Memorandum

To: Dave Merrill
From: Mike Nugent/Inspections Division Director
Date: 3/1/2005
Re: 133 Anderson St.

I have commenced the review of the remainder of the building plans and require the following information or have the following questions:

S1.1

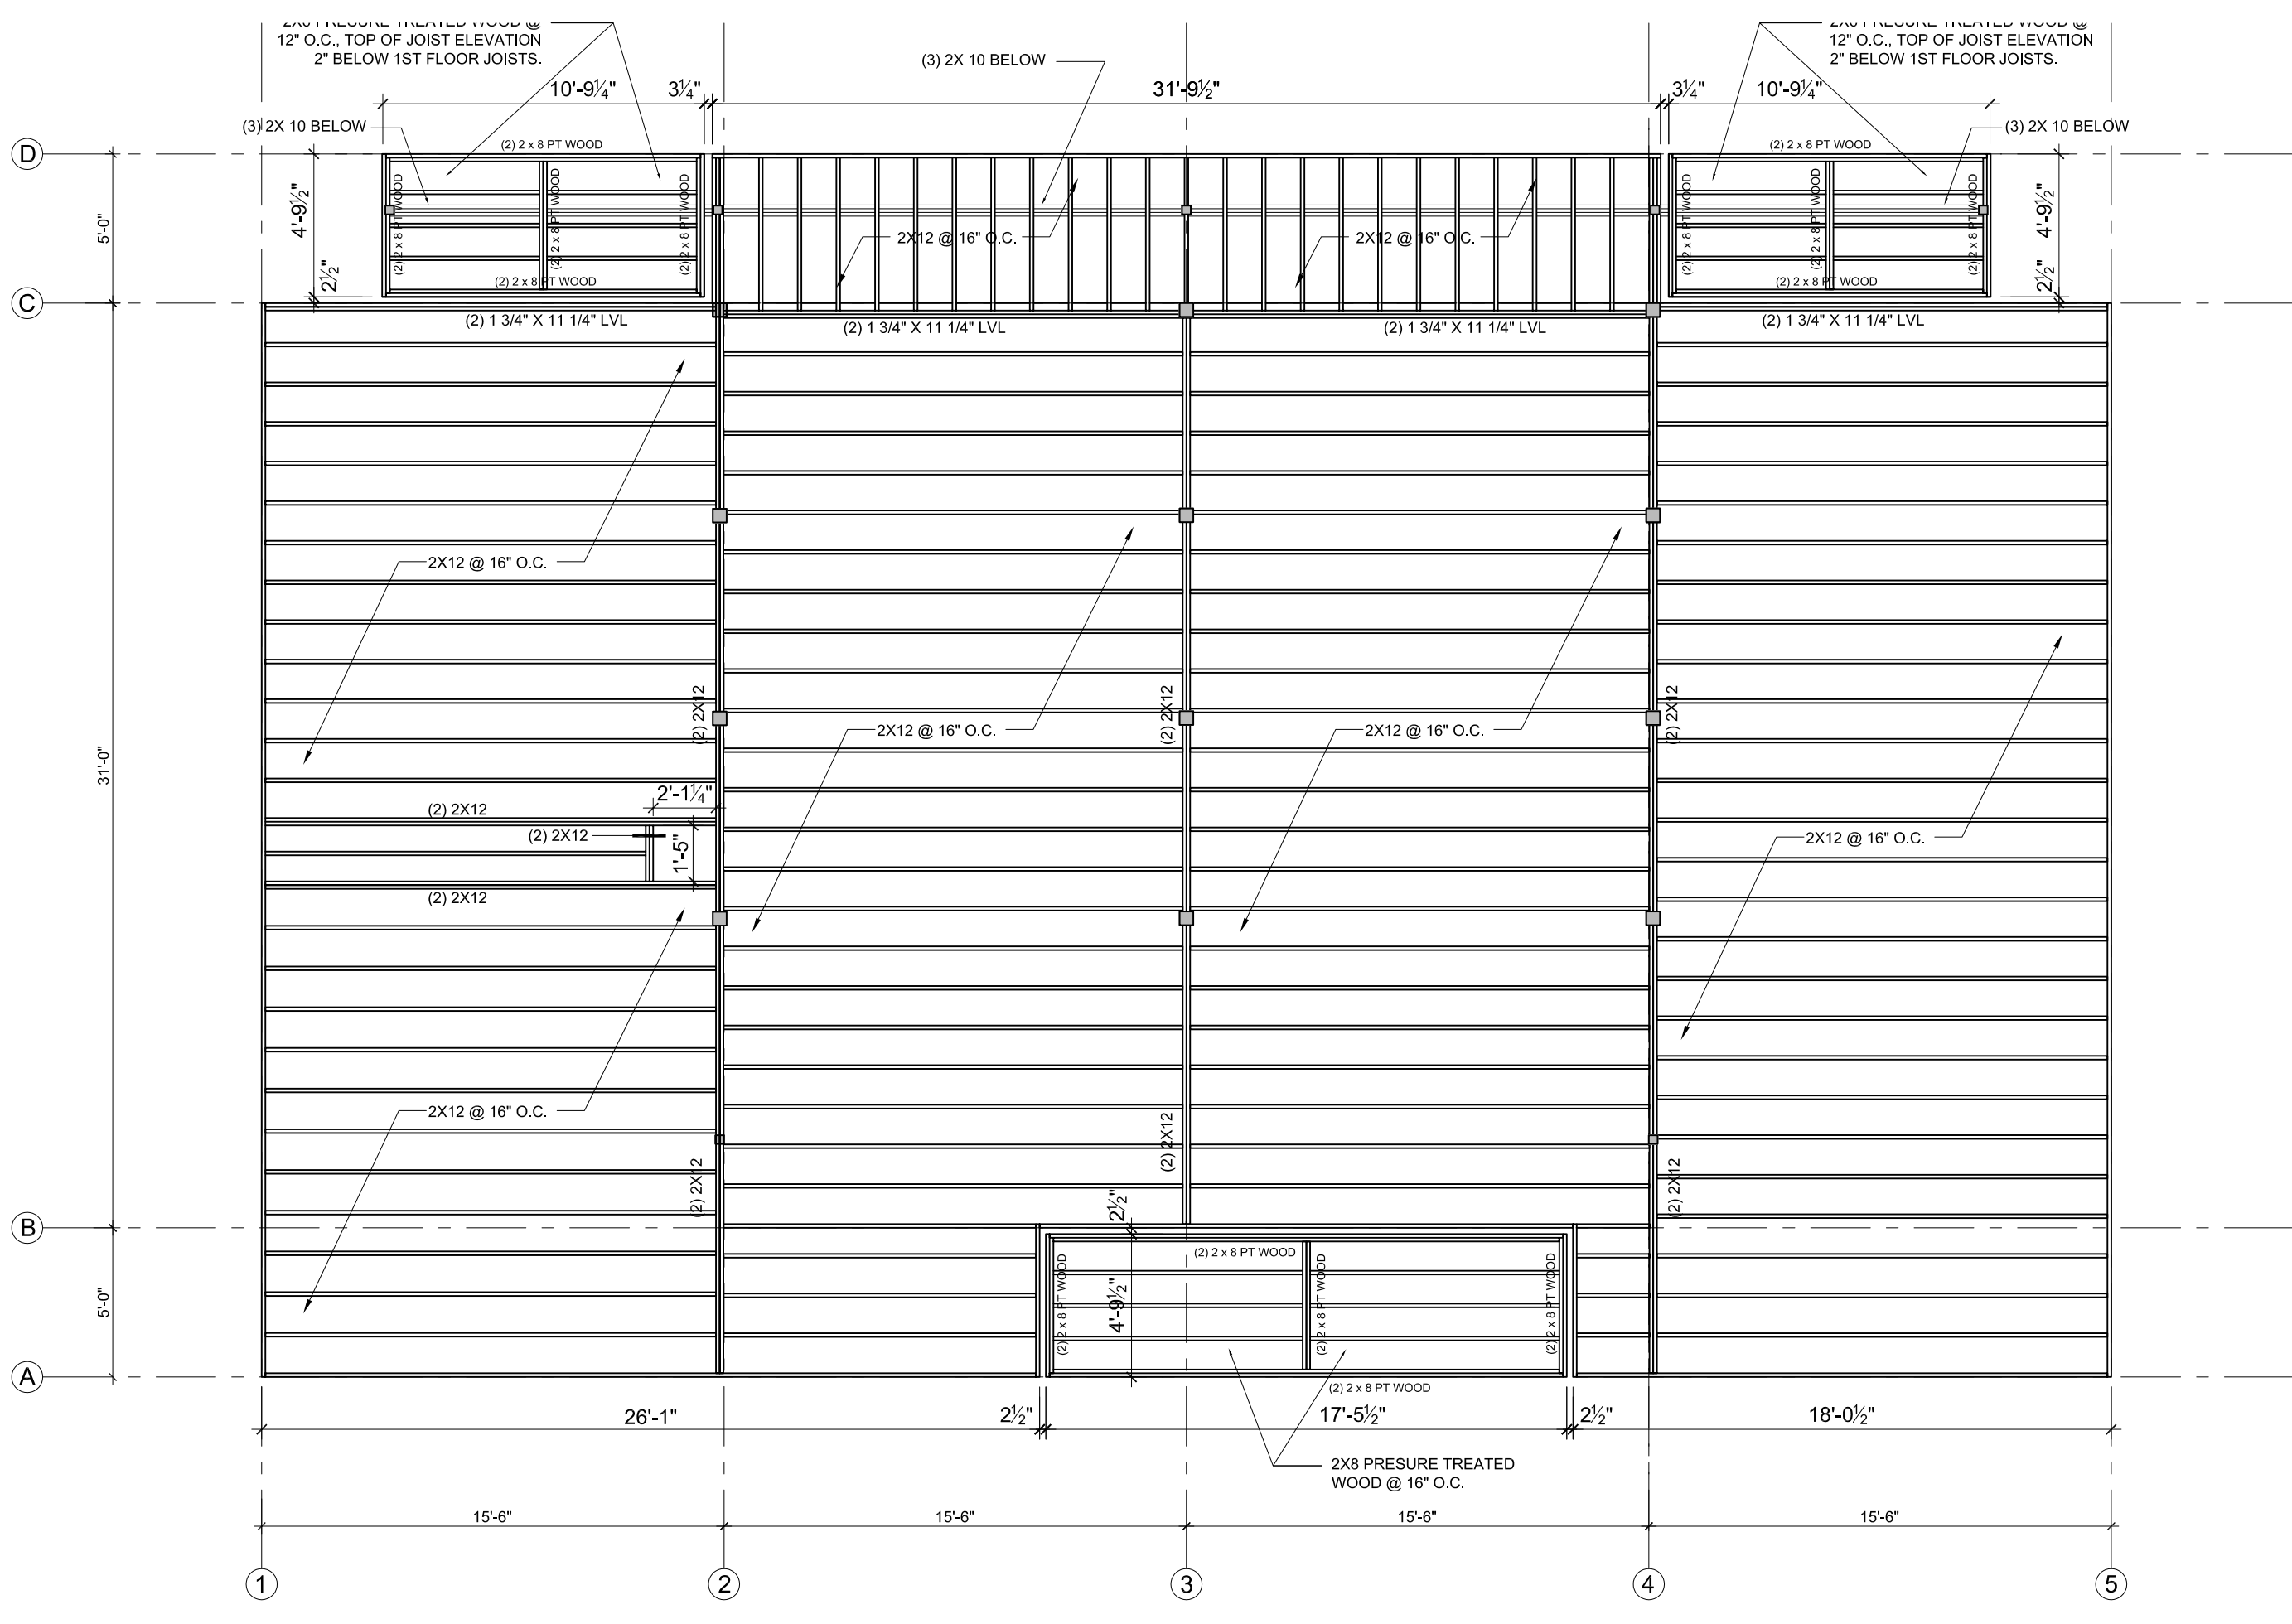
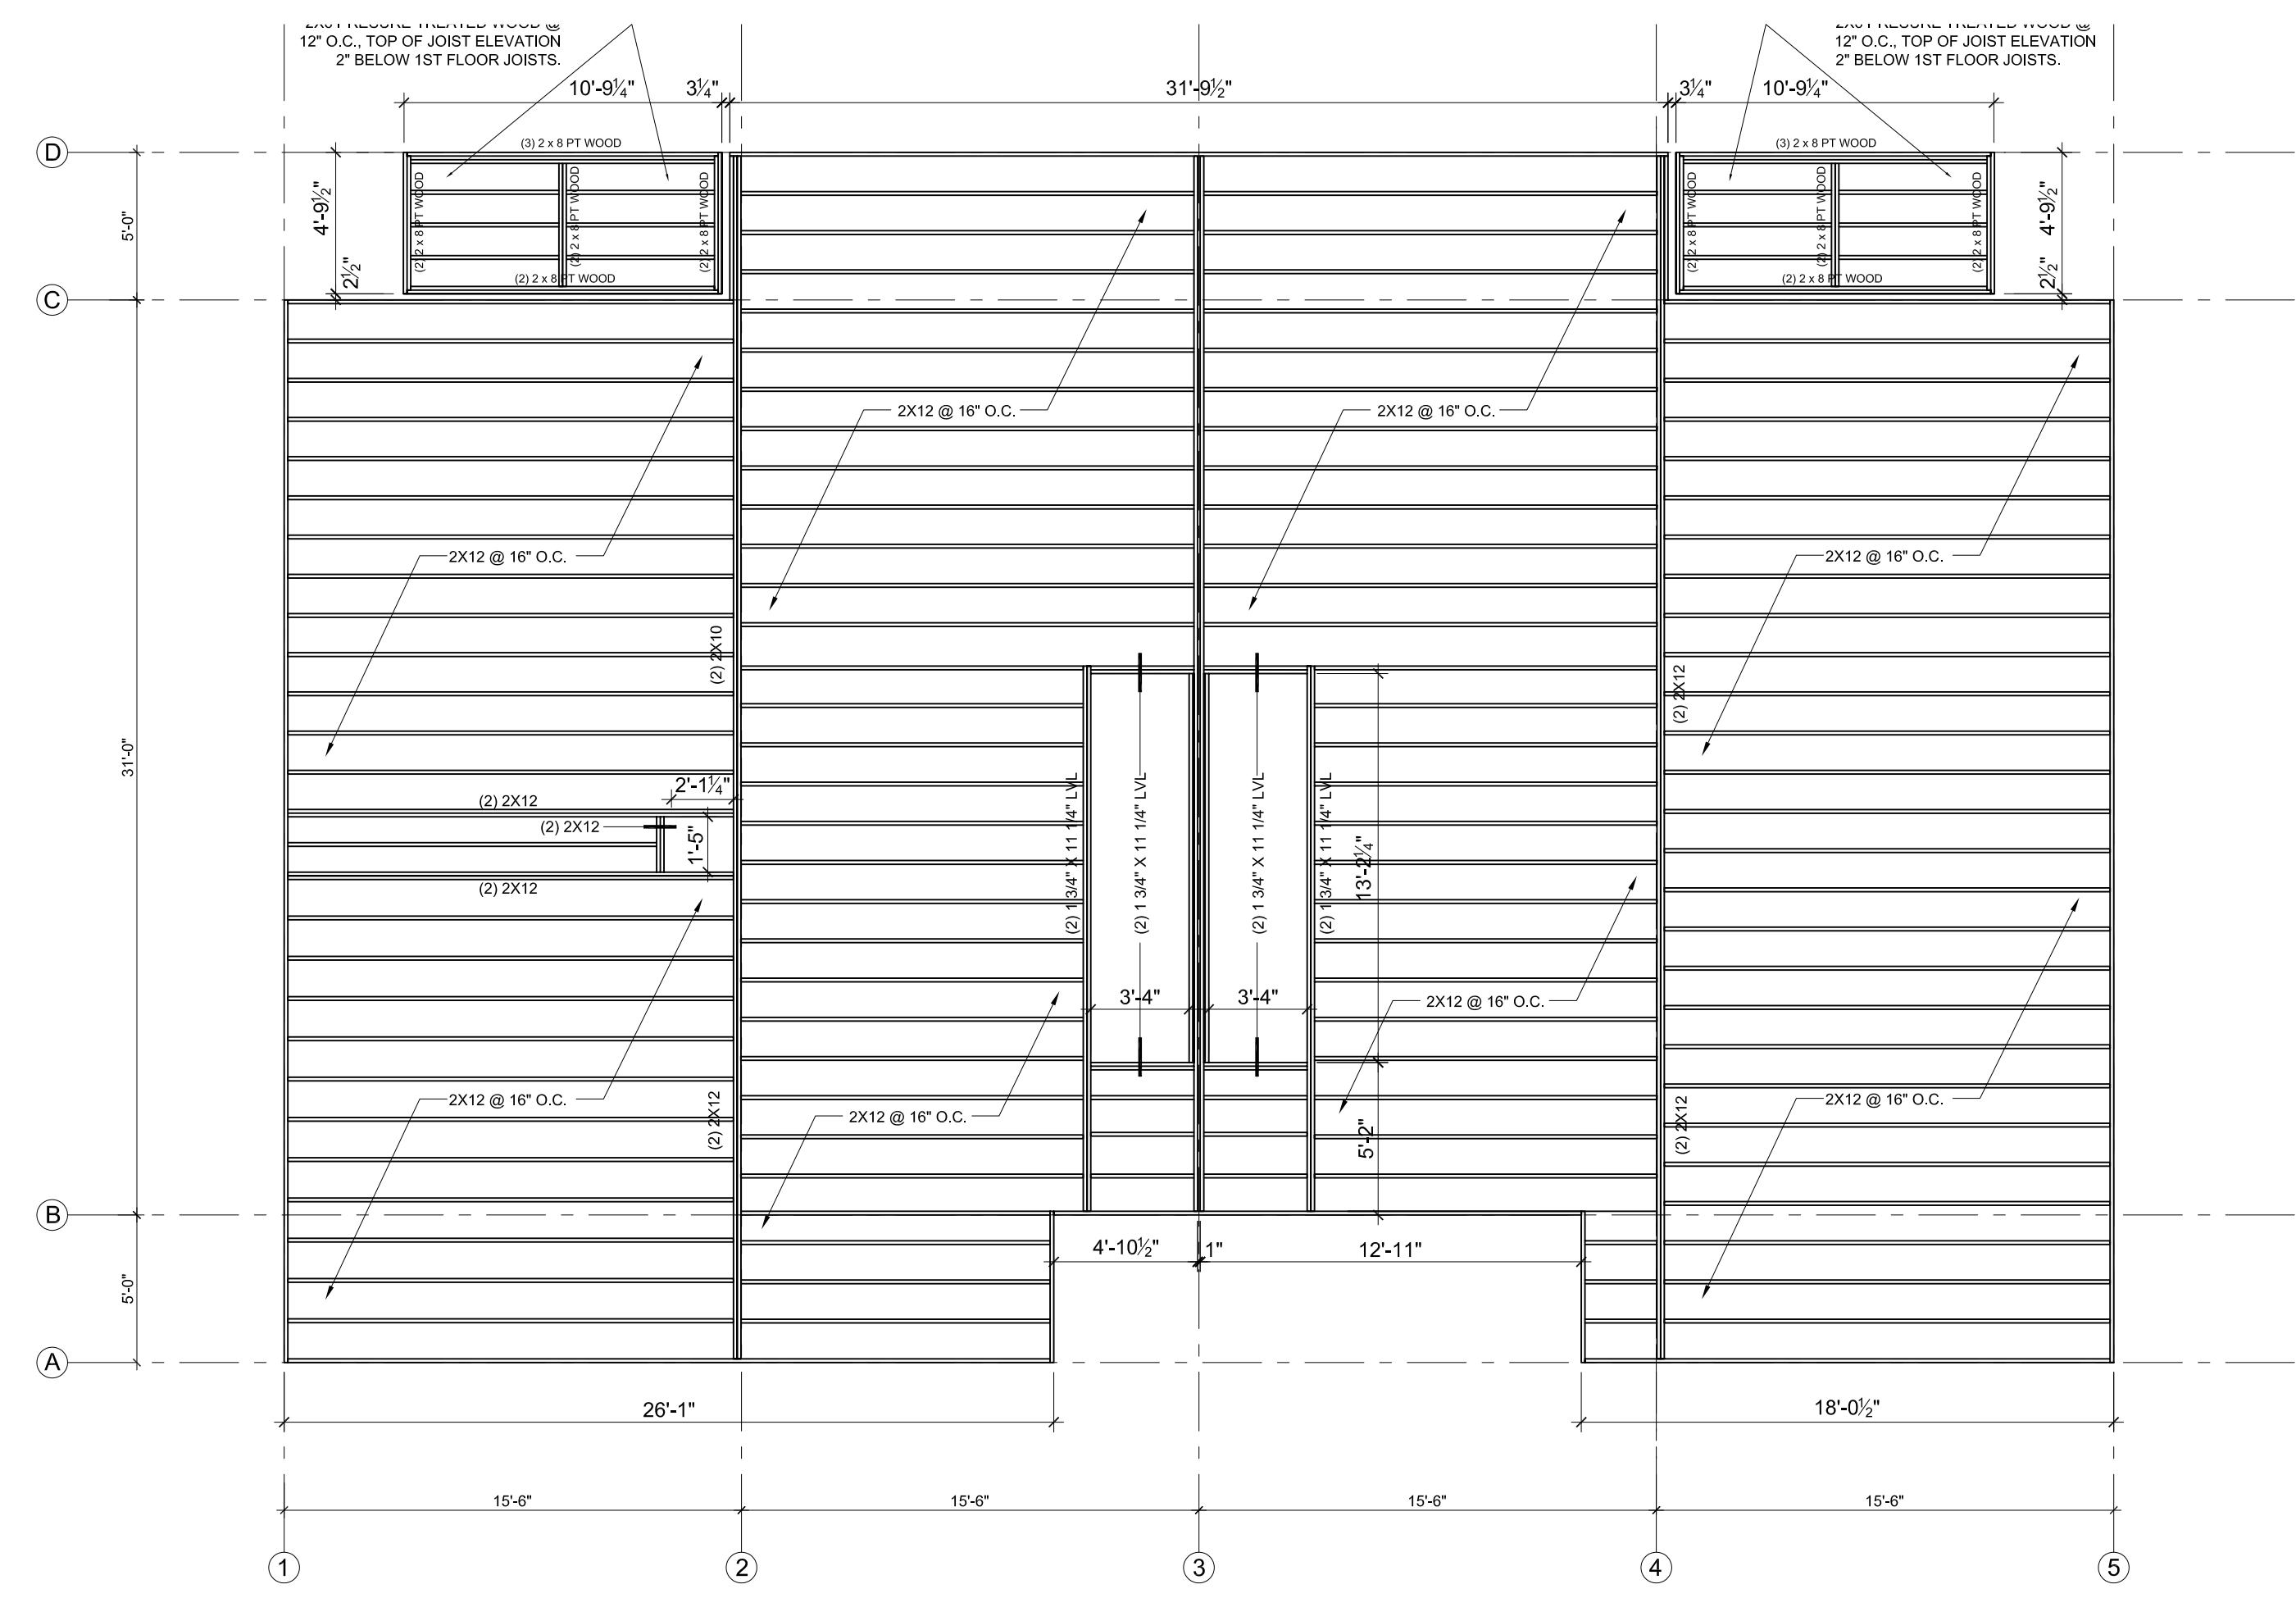
- 9) Details 6, 8 and 9 on S1.1 do not match either rated floor assembly 1E or 1F
- 10) The electrical notes do not specify battery backup in the smoke detectors.
